PLANNING APPLICATION REPORT

REF NO: SS/1/10/

LOCATION: White Cottage
Mill Road
Offham

PROPOSAL: Rear extension

DRAWING	SCALE
PROPOSED ELEVATIONS	1/100
DATE: MARCH 2010	
DRAWN: T. Murray	
DRAWING: 10/17/4	REVISION:

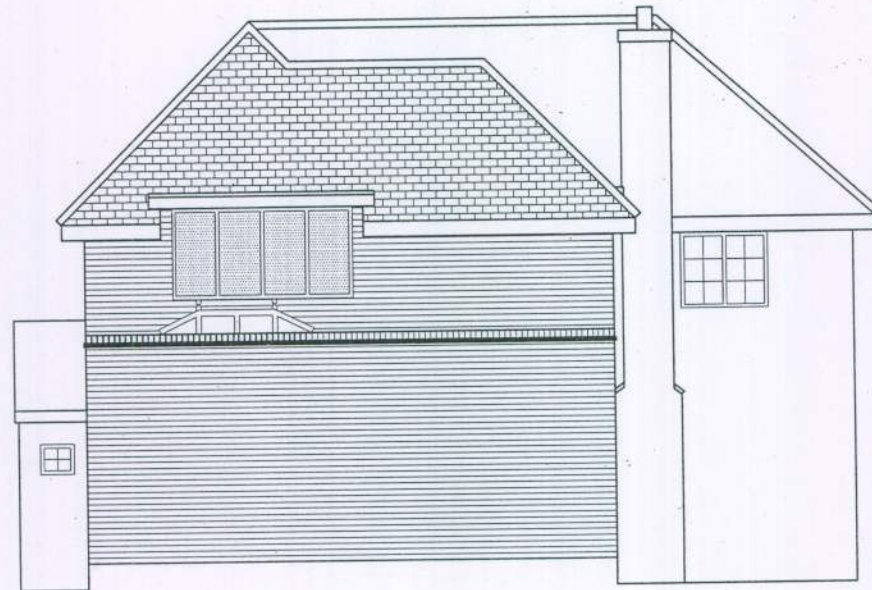
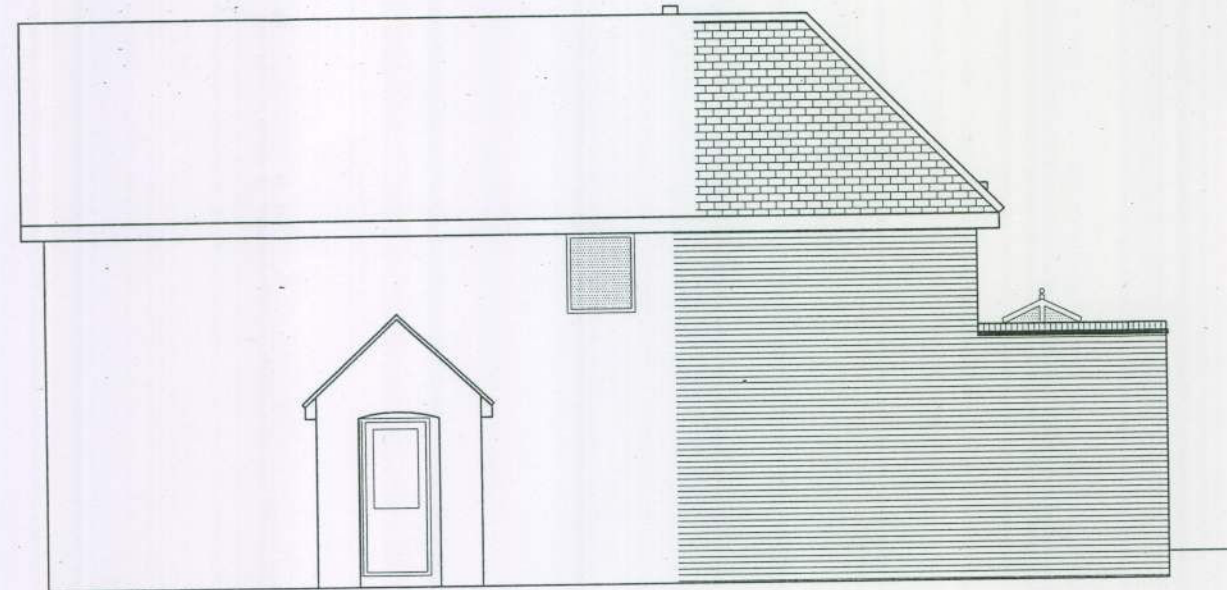
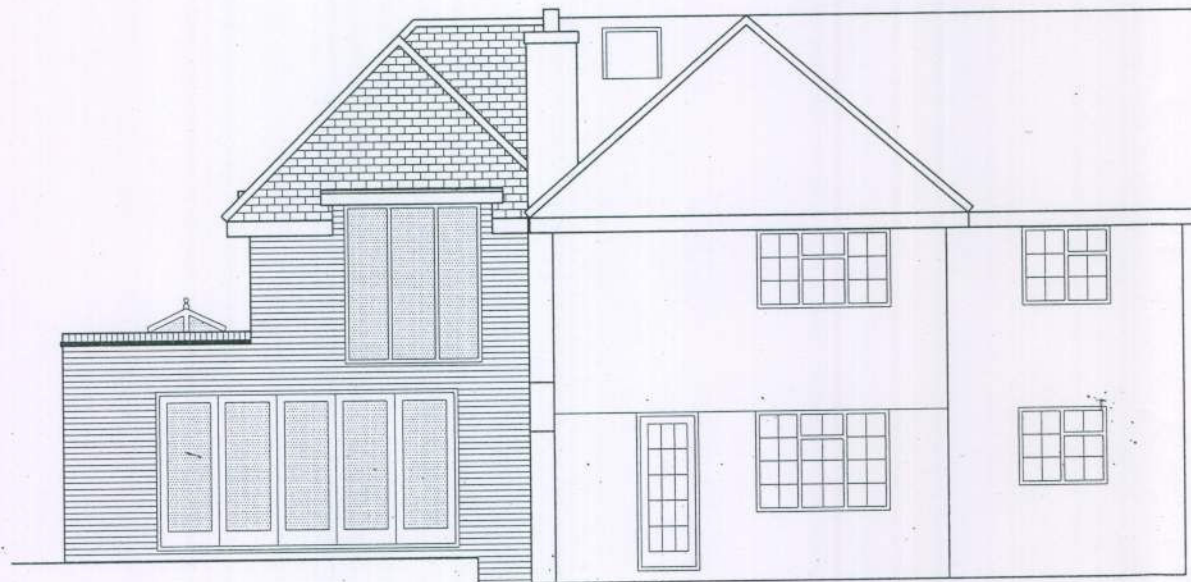
The proposed windows within the rear elevation would face the rear garden of the site with no overlooking of adjoining properties occurring and the fenestration within the west elevation facing onto the side garden of the property. The fenestration in the west elevation would be some 20m from the west boundary of the site with a further 15m to the neighbouring dwelling The Coach House which is considered a more than acceptable distance as to not result in unacceptable overlooking of the neighbouring property.

DRAWING SCALE
PROPOSED GROUND FLOOR 1/50

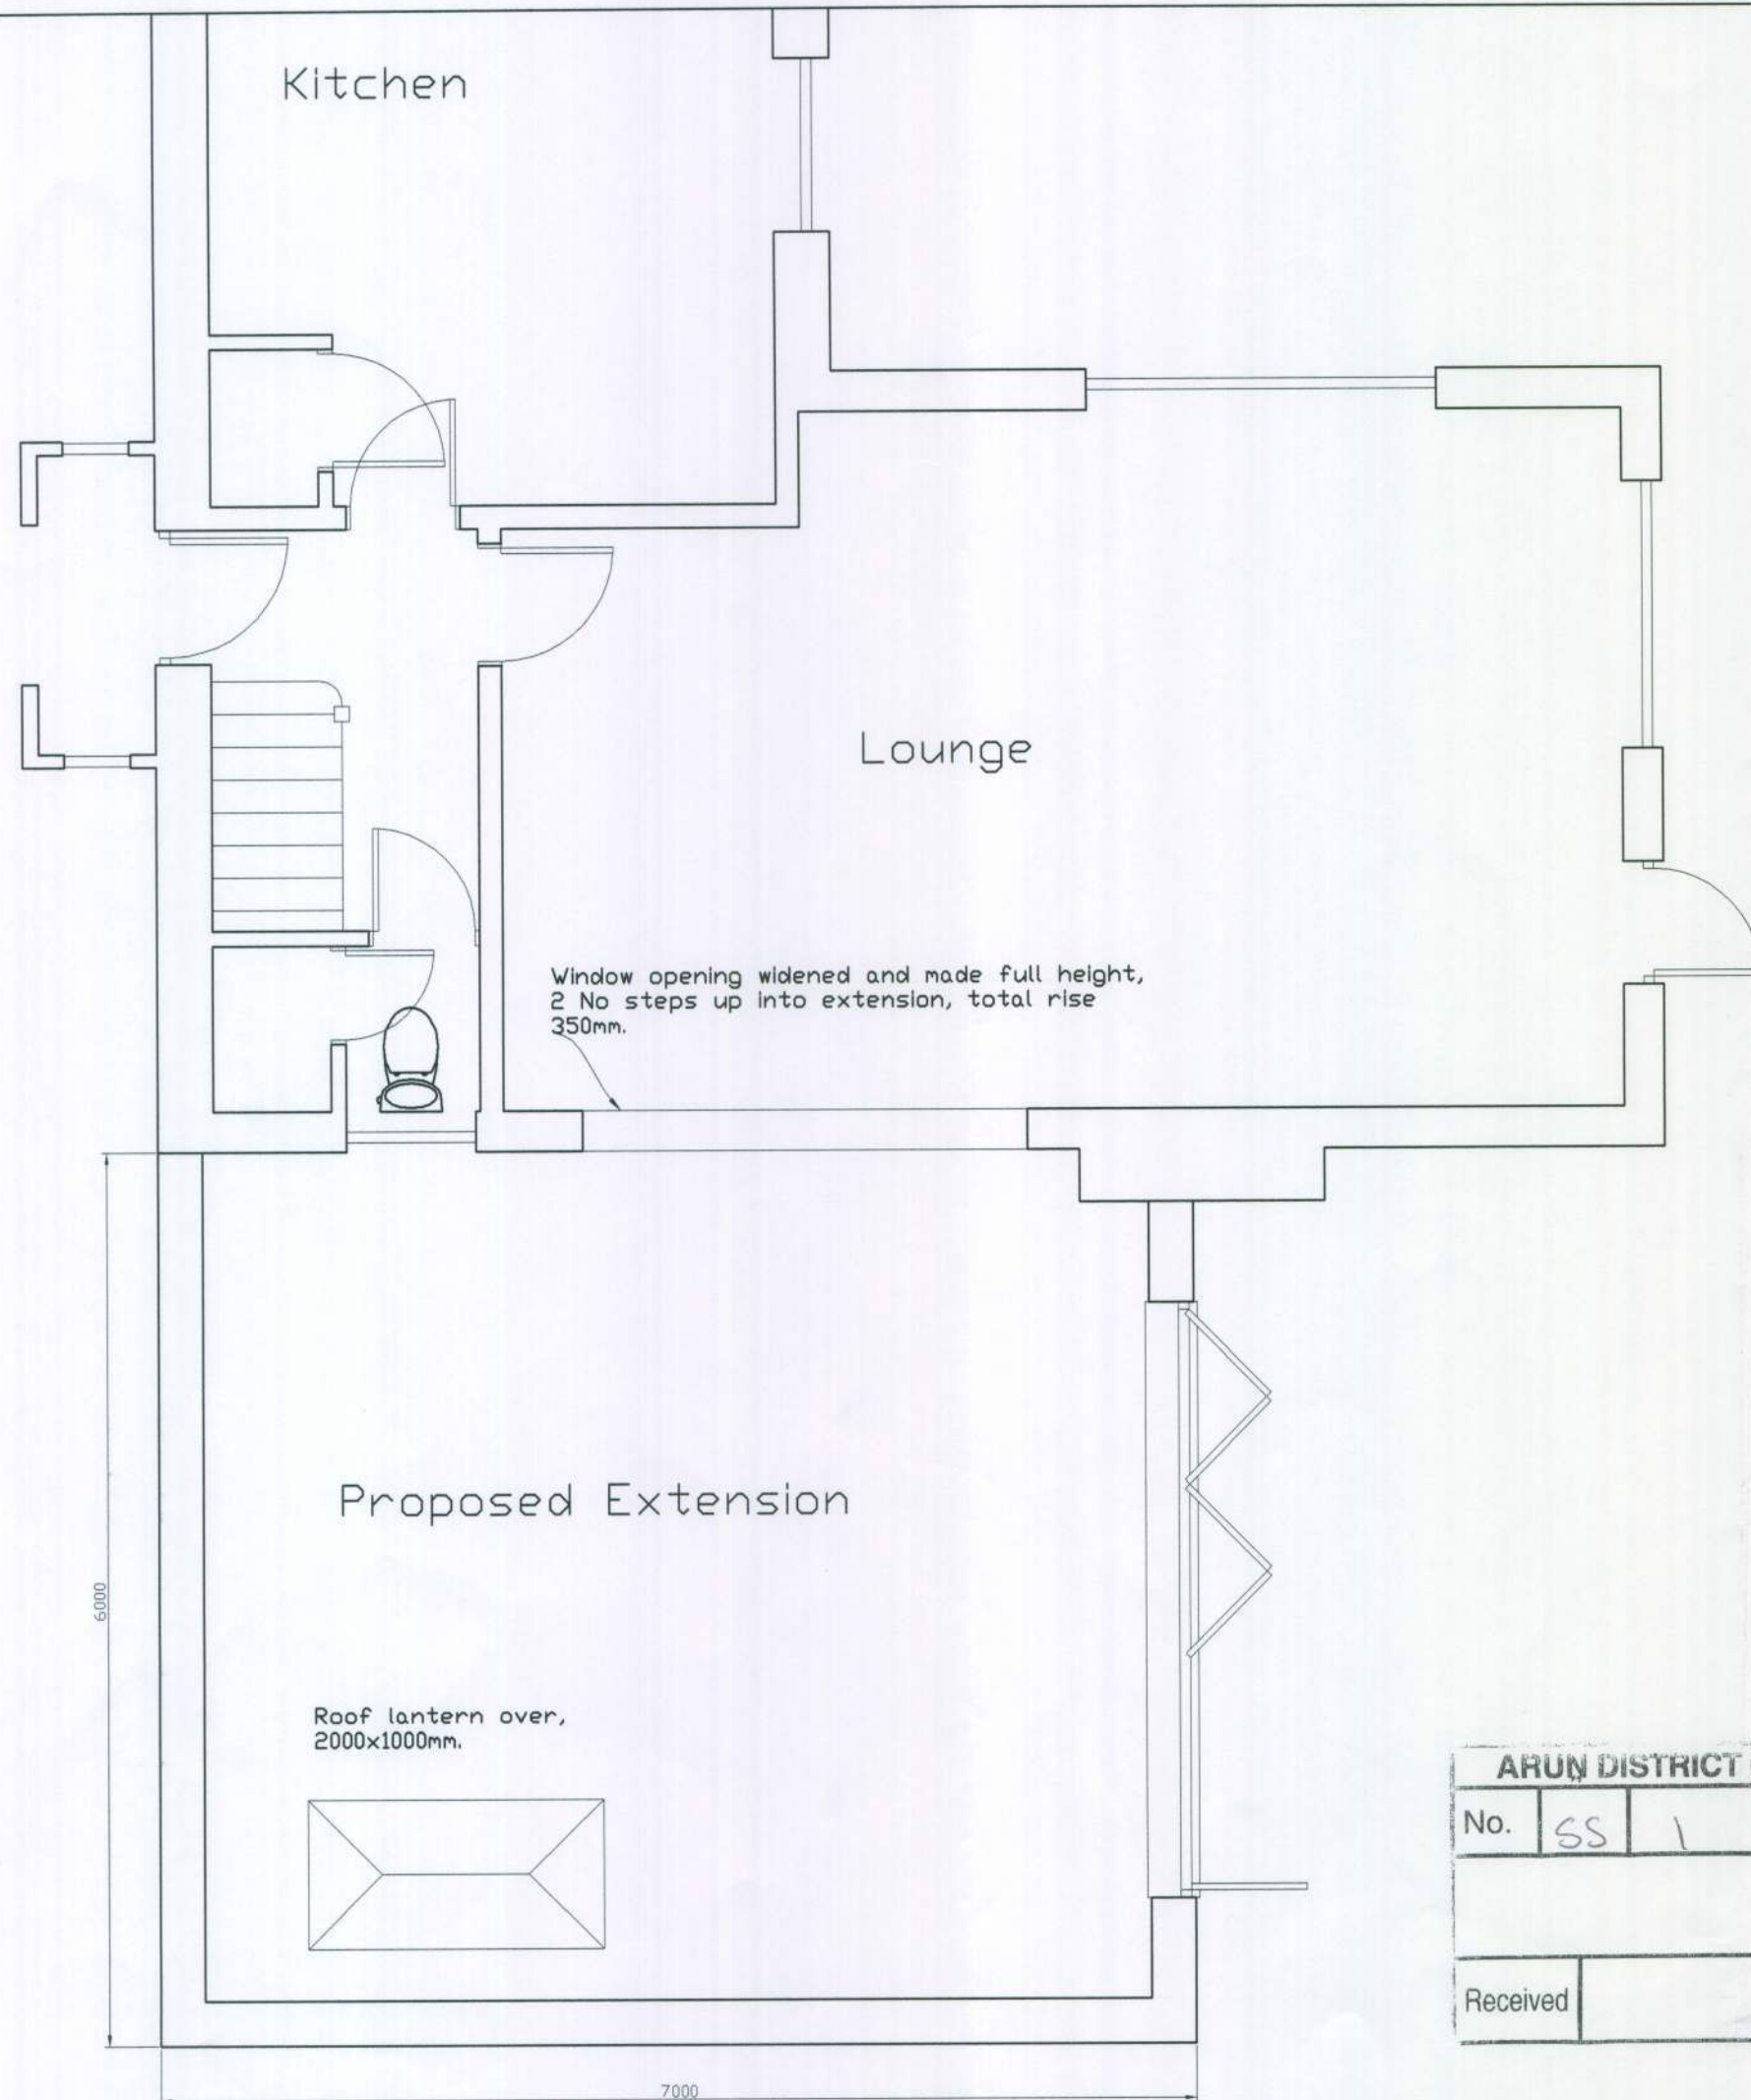
The proposed extension would maintain a distance of approximately 2.5m from the boundary to River Cottage. The single storey section of the addition would extend approximately 2m further than the 2 storey extension. The proposal would only extend some 2m beyond the rear wall of the neighbouring property at ground floor level, therefore coupled with the distance of the addition from the boundary the proposal does not conflict with the 45 degree rule nor impact upon the amenity of the neighbouring property by way of the overbearing or loss of light.
